Noise Impact Assessment

The comments below relate Vipac Engineers & Scientists Report 29N-14-0048-TRP-472764-0 *Tattersall Lander PTY LTD Bobs Farm Sand Mine Noise Impact Assessment* (dated 09 June 2015), herein referred to as the Vipac noise report.

Air Impact Assessment

The comments below relate Vipac Engineers & Scientists Report 29N-14-0048-TRP-516792-2 *Tattersall Lander PTY LTD Bobs Farm Sand Mine Air Quality Assessment* (dated 18 September 2018), herein referred to as the Vipac air report

Figure 7-1 – Proposed Mitigation

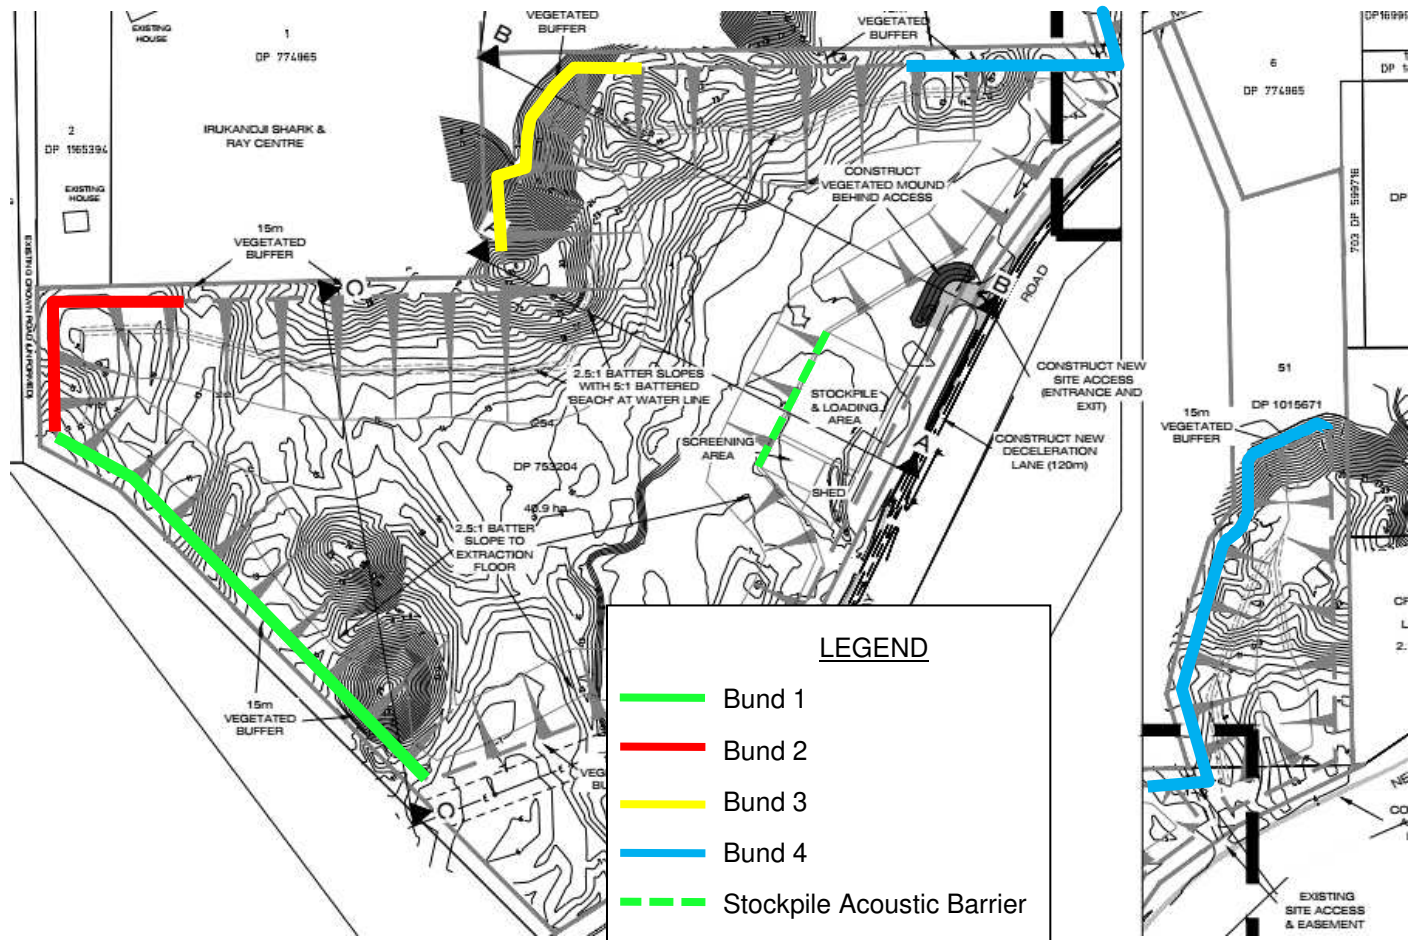
- Location and extent of proposed mitigation is not clear from the Vipac noise report.

- Works required to address Vipac noise report assumptions and recommendations have not been outlined (specifics on earth mound placement, maintenance/design of mound or sound power emission verification and ongoing compliance management for example)
- Peak operations includes up to 200 road transport trucks. The number of trucks of site at any one time requires assessment. It is not clear if this has been undertaken. With a Sound Power Level of between 118 to 110 dB(A) as per Table 12 of the Vipac Noise Report, having an additional truck manoeuvring on site would increase potential off-site noise impacts.
- With mitigation, exceedance of project noise limits is present (with project noise limits set being commented on above).
- **Outcome**

Figure 7-1: Location of Sources [Tattersall Lander]

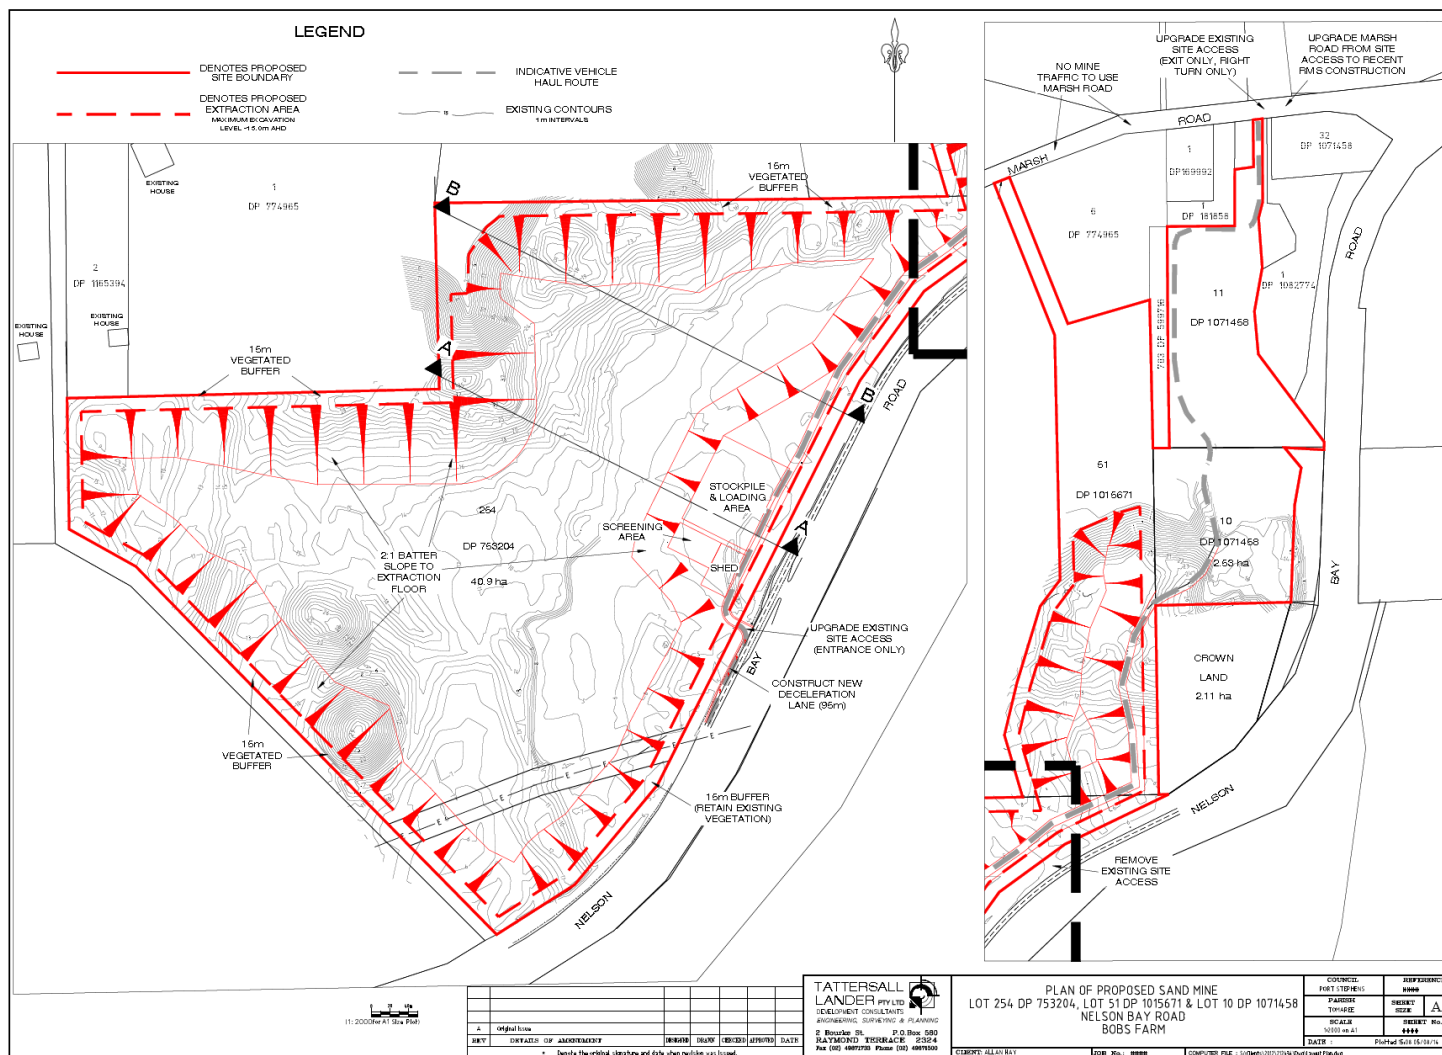
- Potentially affected sensitive receptor locations are not consistent with the referenced noise impact assessment.
- Number and location of modelled air sources (as modelled) is not clear from the Vipac air report.

- Emissions would be present from a number of discrete points from identified fugitive activities (Section 7.3 of Vipac air report) – the conveyor as a line source and at end point for example; or loader handling material then dumping; active face and working face of stockpile; ‘mining’ is a broad term and application of same within Vipac air report is not clear. Specific sources of emissions should be included and assessed – broadly grouping sources may be overly simplistic and underrepresent potential off site impacts.
